Condition 11- Surface Water Drainage Design

Application No: **CM/11/21/DOC**

Registered: 5th March 2021
Site Address: Scyld Horsemere Green Lane Climping BN17 5QZ
Description of Works: Approval of details reserved by condition imposed under CM/21/19/PL relating to conditions 11-surface water drainage scheme, 12-discharge of flows to water courses or for the culverting, diversion, infilling or obstruction of any water course on or adjacent to site & 13-maintenance and management of surface water drainage system.

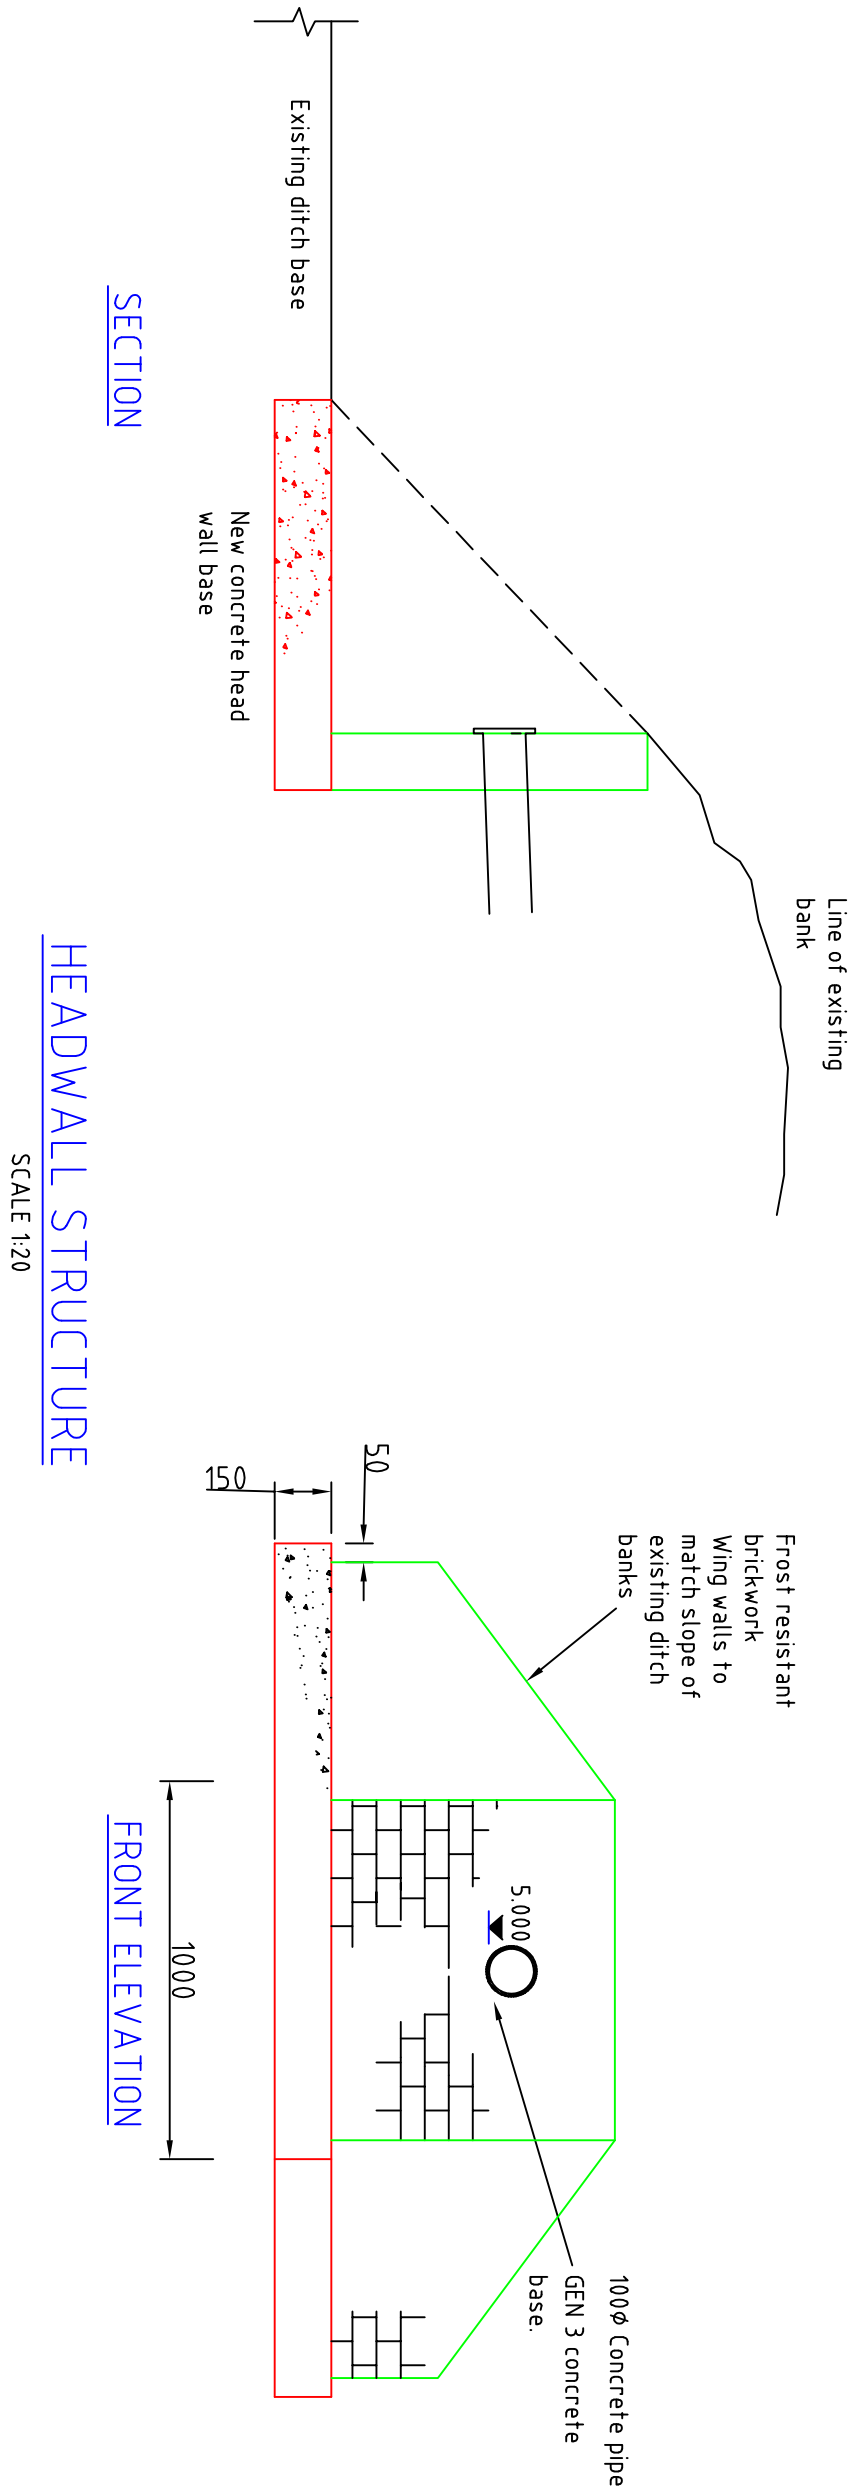
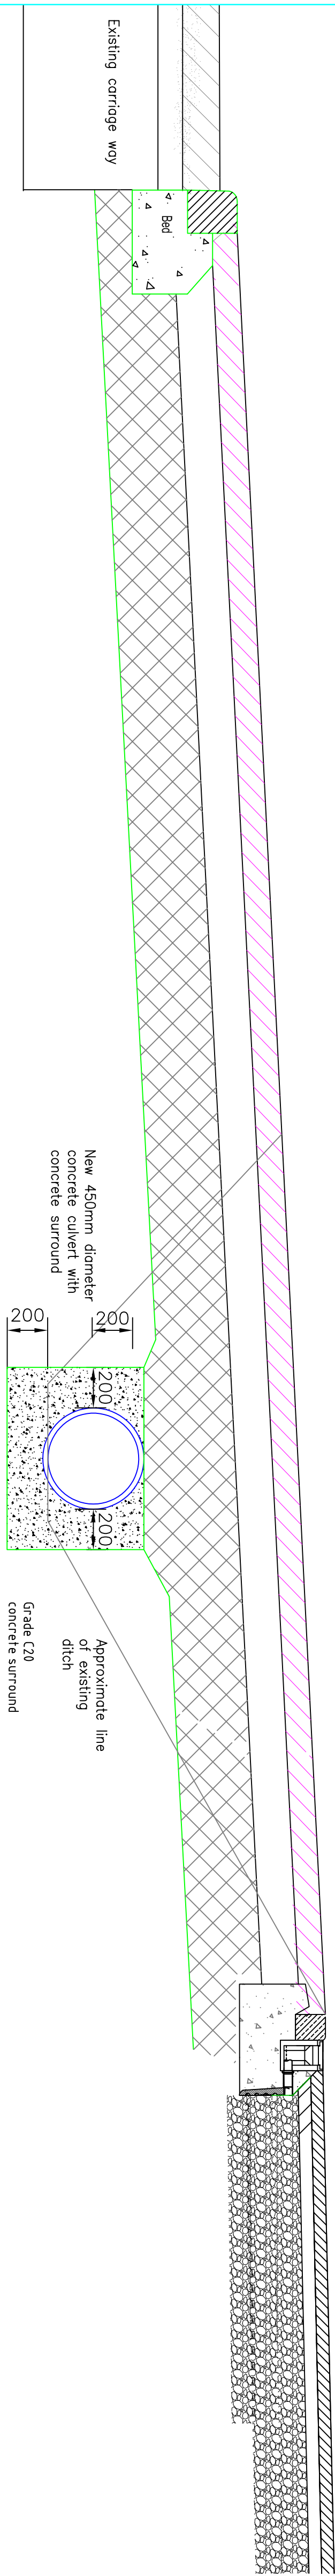
3. The long section on the drainage details sheet 1 refers to a hydrobrake with a restriction of 2.0l/s, which conflicts with the calculations, other details and layout (although addressing point 1 will affect these). This is now correct after the revised calculations, other details have been updated accordingly. See comment below.

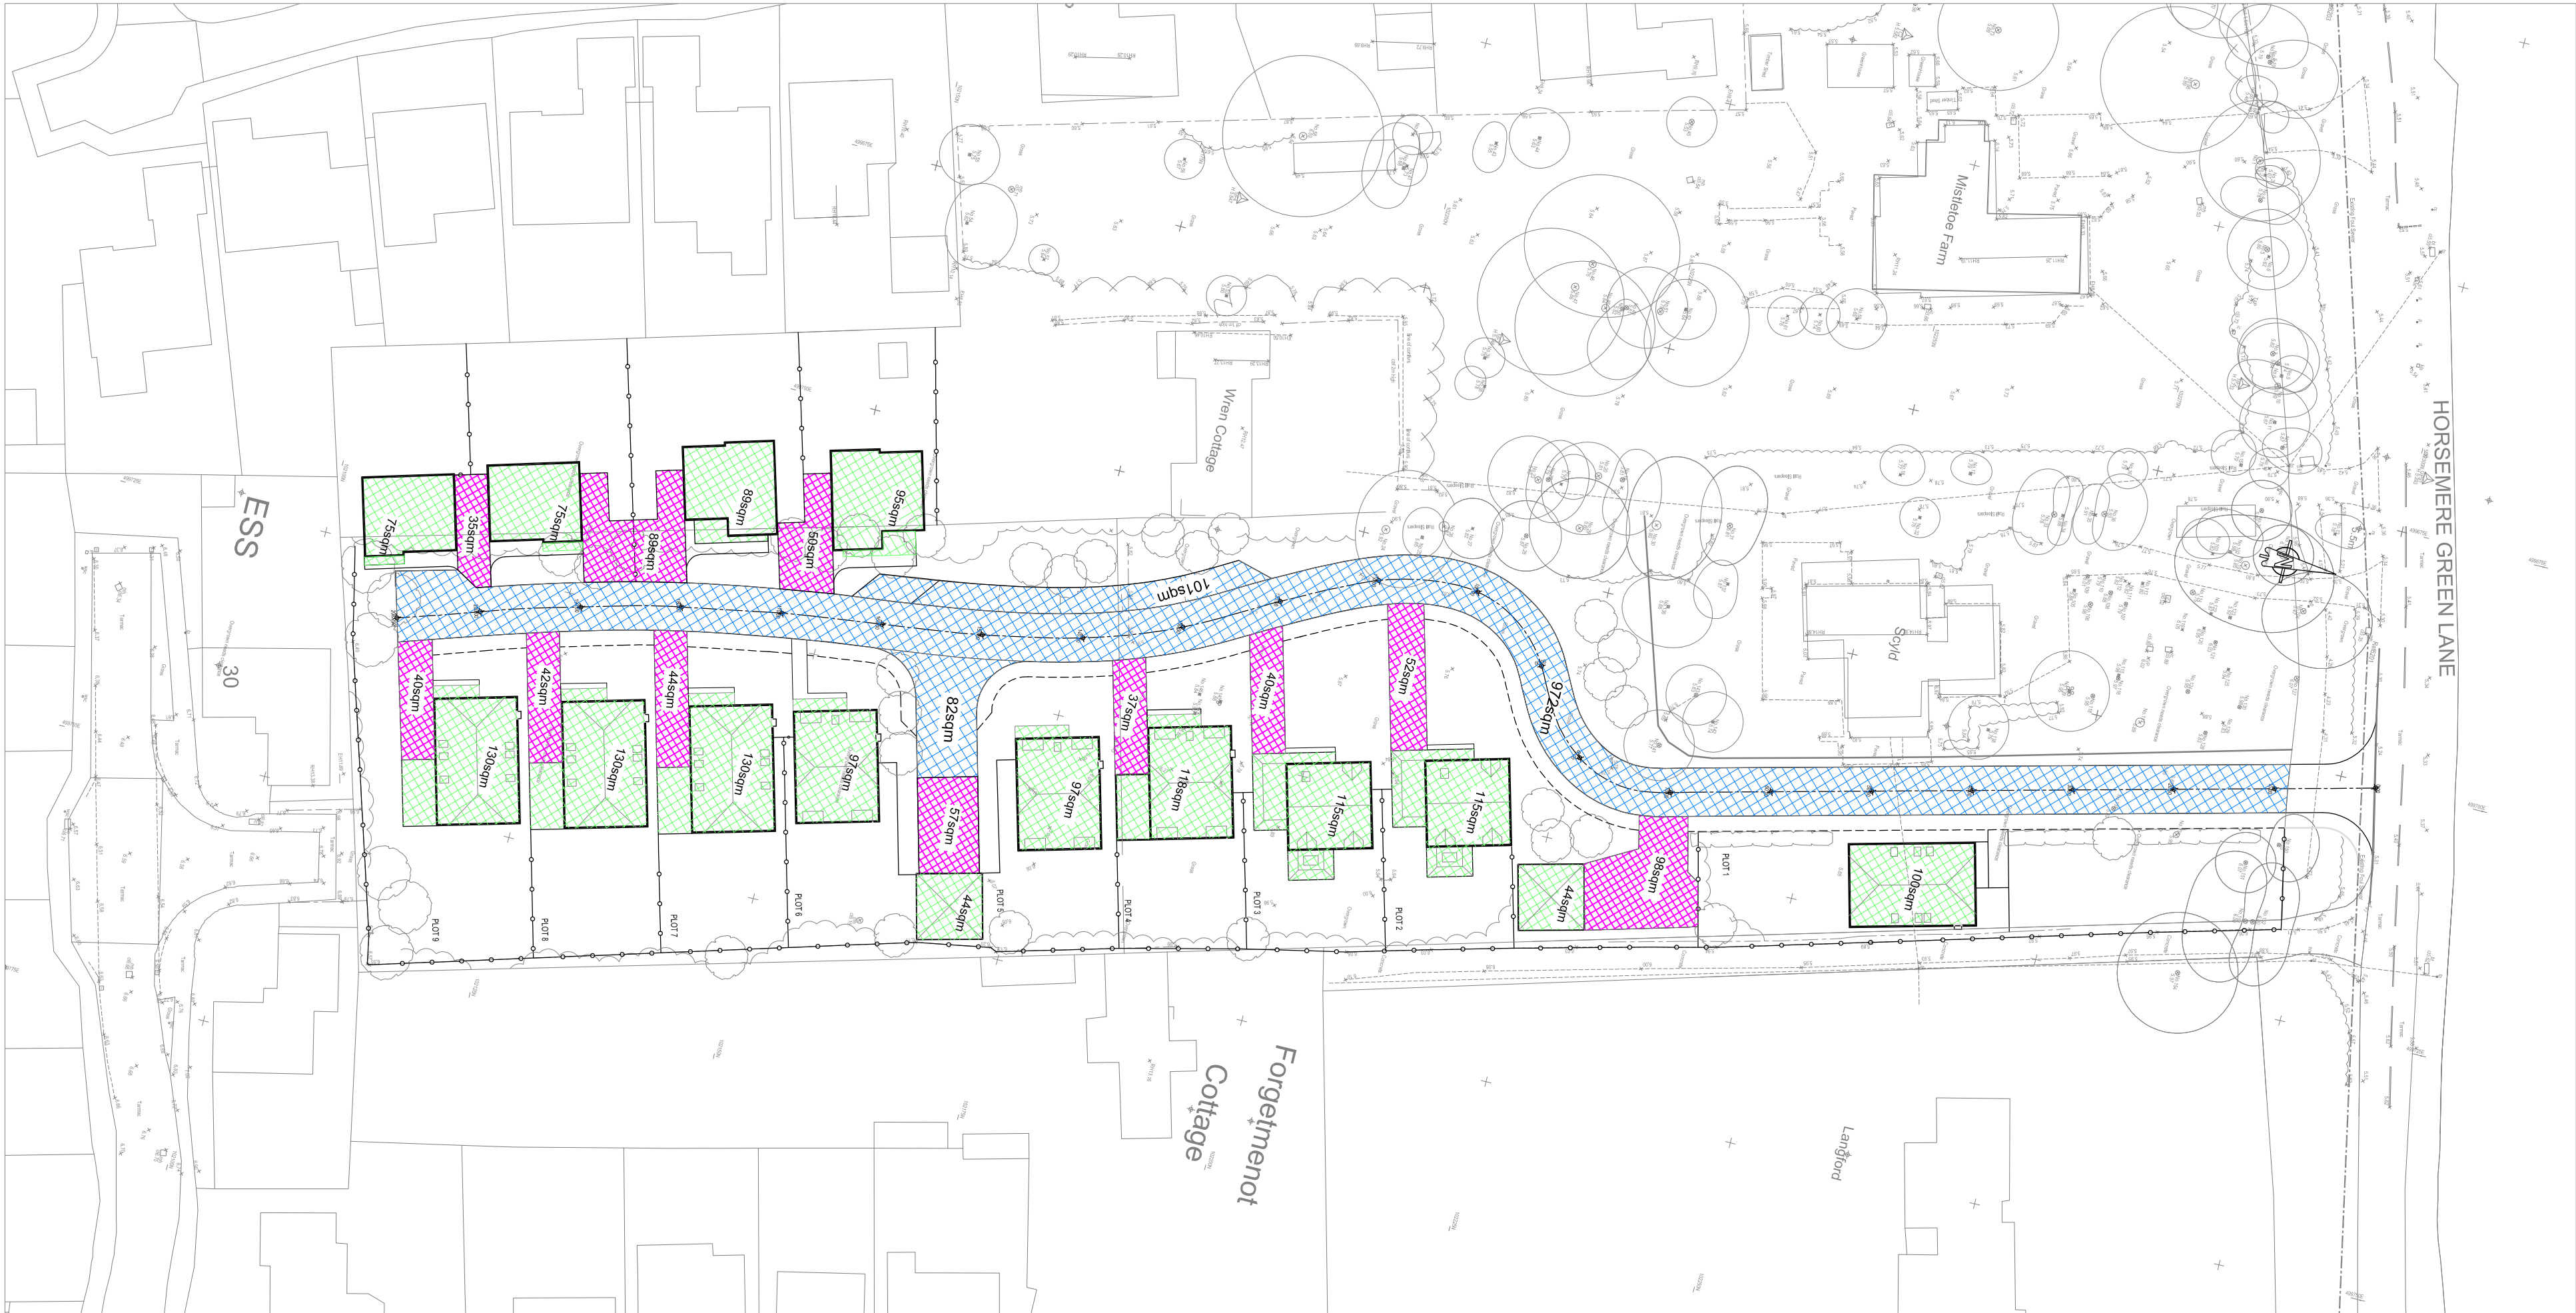
2. The impermeable areas plan appears to use an old layout, not the latest layout as approved under CM/55/20/PL. Please provide an updated impermeable areas plan. Updated plan attached to be read alongside the new calculations / drainage modelling. *Okay, point closed.*

DETAIL 1: TYPICAL SECTION SHOWING NEW ENTRANCE AND EXISTING HIGHWAY WITH NEW CULVERT

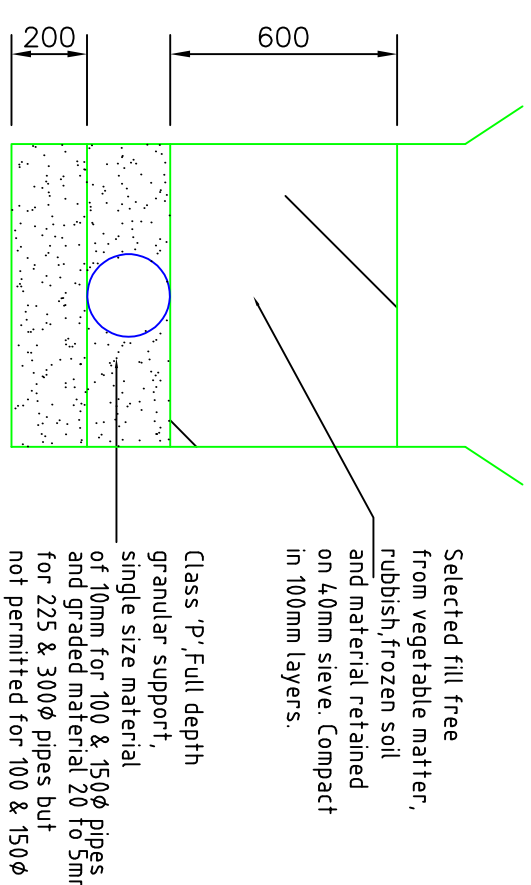
1. Please supply further details of the proposed culvert, i.e. diameter, invert level, and construction details- including headwalls. We have put more information on the drawing on the details drawing. *Two sets of drainage details sheet 2 have been provided, please confirm which version should be reviewed.*
2. It is stated on the plans that the culverting has been agreed, we do not believe this to be the case. Please supply evidence that an application for land drainage consent has been made for both the proposed culverting and outfall headwall. This has been applied for and we are issuing new information and the application is ongoing. Okay.

HEADWALL STRUCTURE FOR OUTLET PIPE

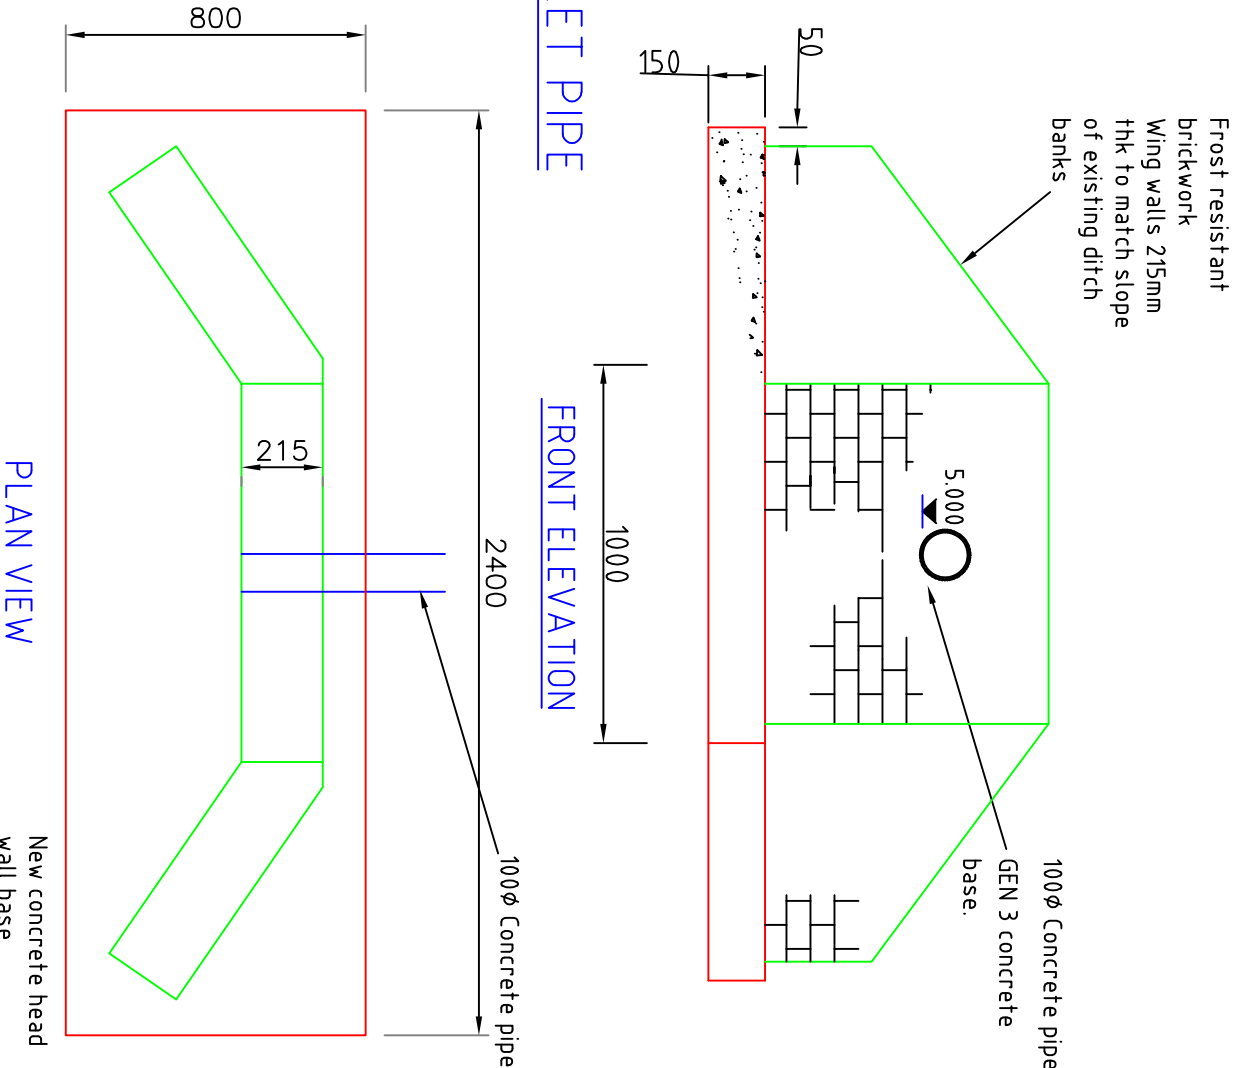
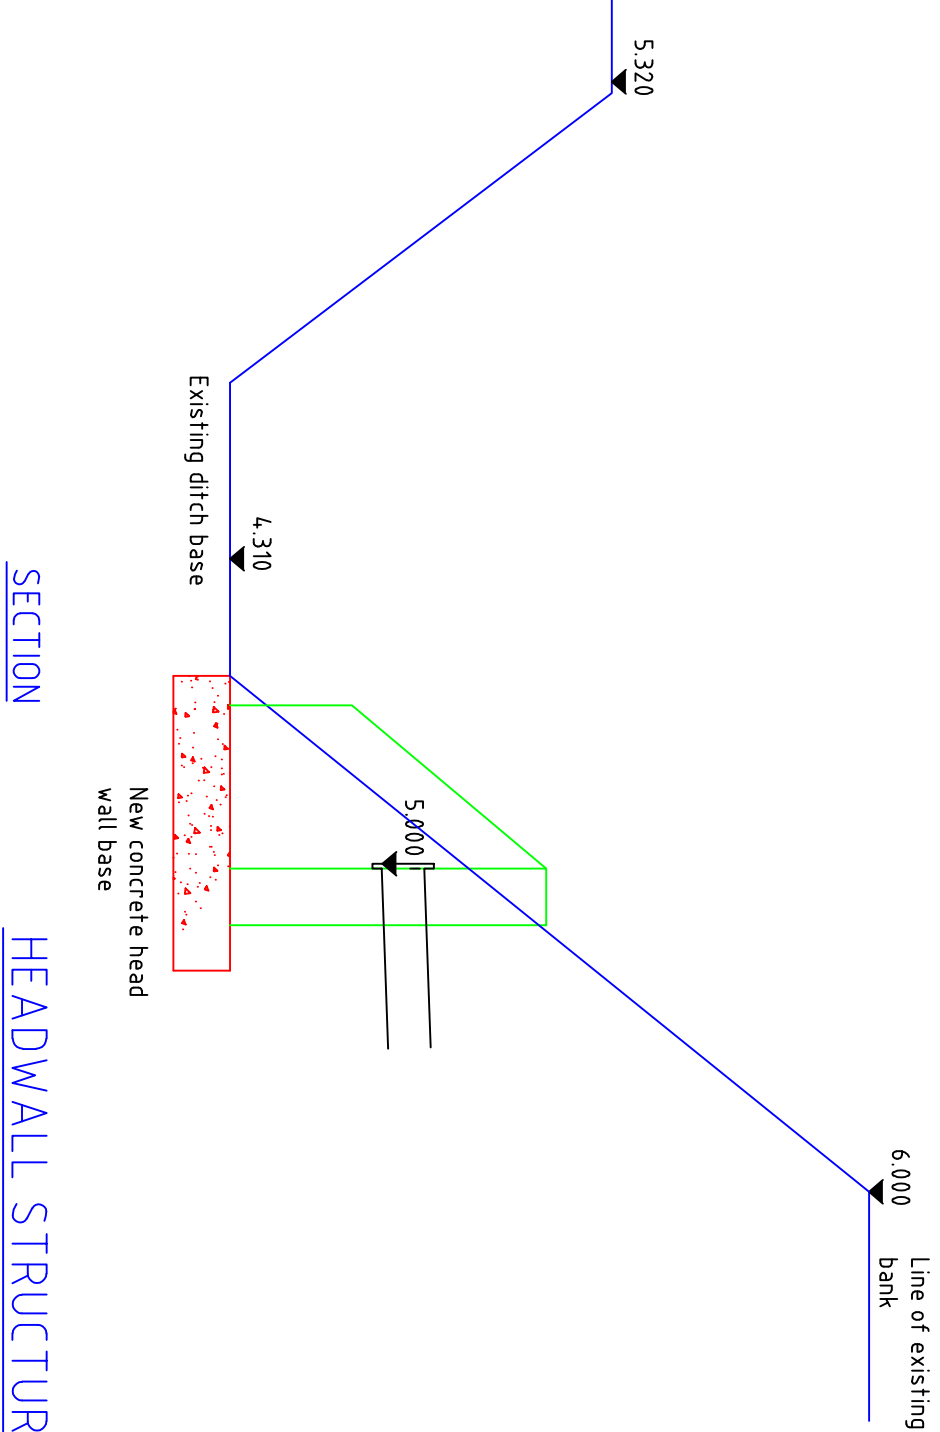
8. Please provide site specific construction detail drawings of the proposed headwall, this should include a plan and full cross section through the ditch. All headwall drawings should indicate existing bed level, and top of bank level. Detail updated. *Two sets of drainage details sheet 2 have been provided, please confirm which version should be reviewed.*
